Brackett St Vet Clinic Sign

Thu, Jun 16, 2016 at 3:33 PM

Drawing #: 2      Sales Rep: RN

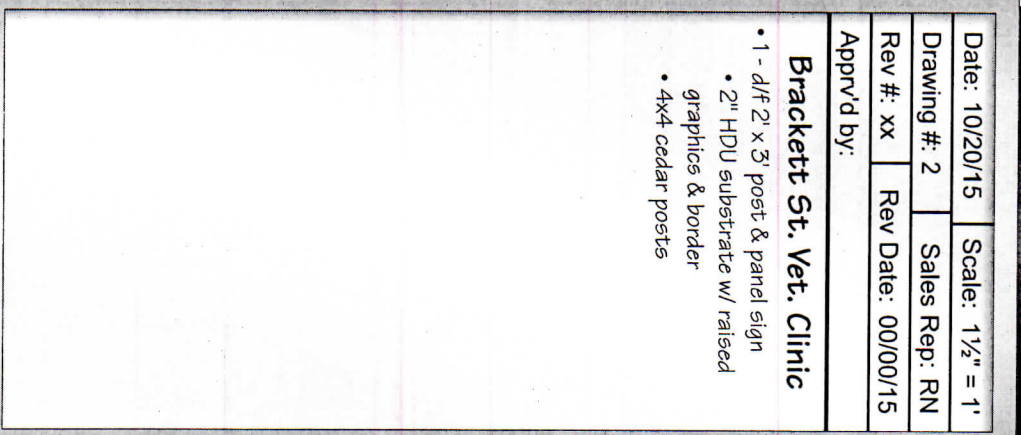
Quick question, in the application the height of the new sign is listed as "6 feet" - is this just the height above the fence, or the height from the ground? I need the measurement from the ground, total height from grade is supposed to be 16 feet or less. Not sure what the current sign's height is.

It's the height above the 4' fence
